Harnett County Government Complex
307 Cornelius Harnett Boulevard
Lillington, NC 27546

Re: Status of Improvement Permit Application HTE # 10-5-25286

An attempt was made to evaluate your property on 9/22/10 for the purpose of issuing an Improvement Permit. The evaluation could not be completed for one or more of the following reasons.

SITE PLAN APPROVAL

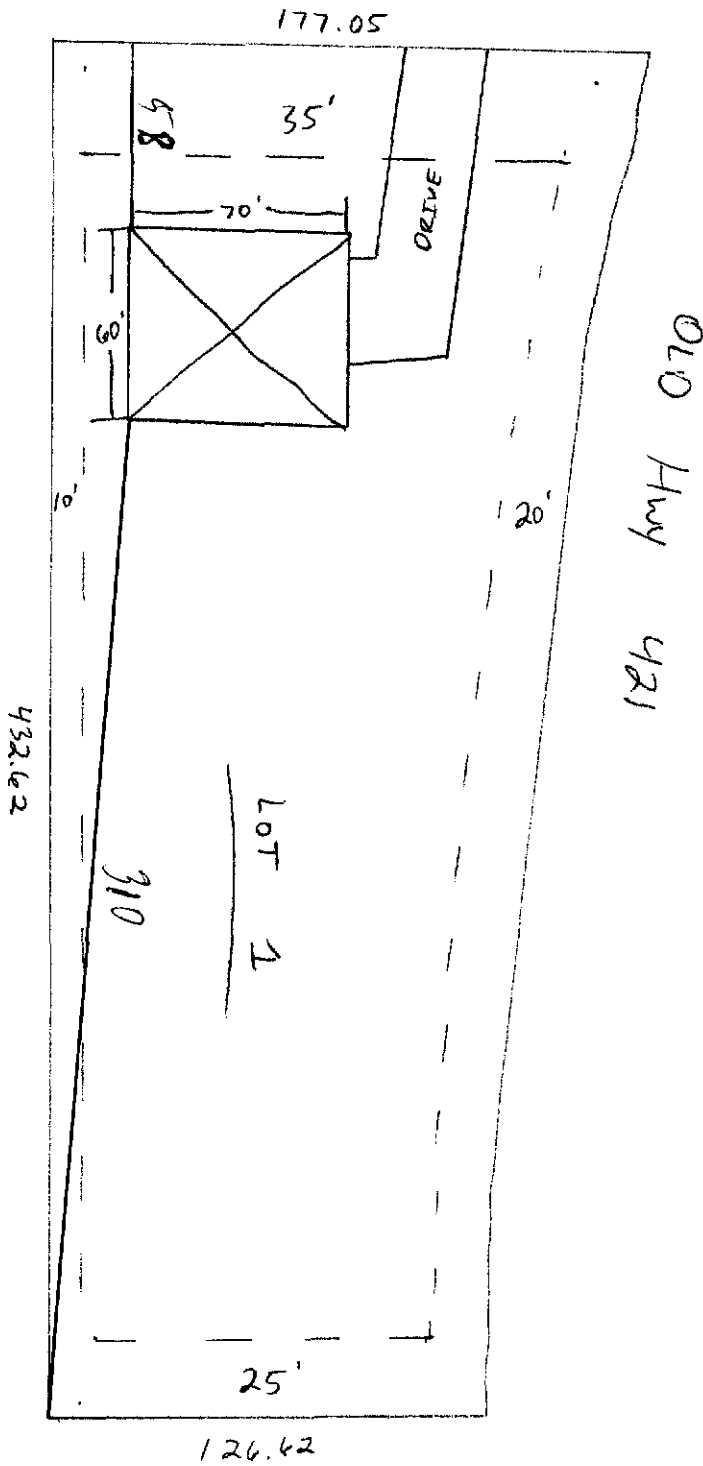
- 1. Use pink flags to mark property lines and irons that are set by surveyor need to be visible. (\$25.00 fee incurred)
- 2. Use orange flags to mark house corners- Need To Match Site Plan. (Site plan front set back states 58 ft. actual 82 ft.)
- 3. Directions not clear to property (\$25.00 fee incurred)
- 4. Property needs only brush or vegetation removed
- 5. Backhoe pits required
- 6. Other-
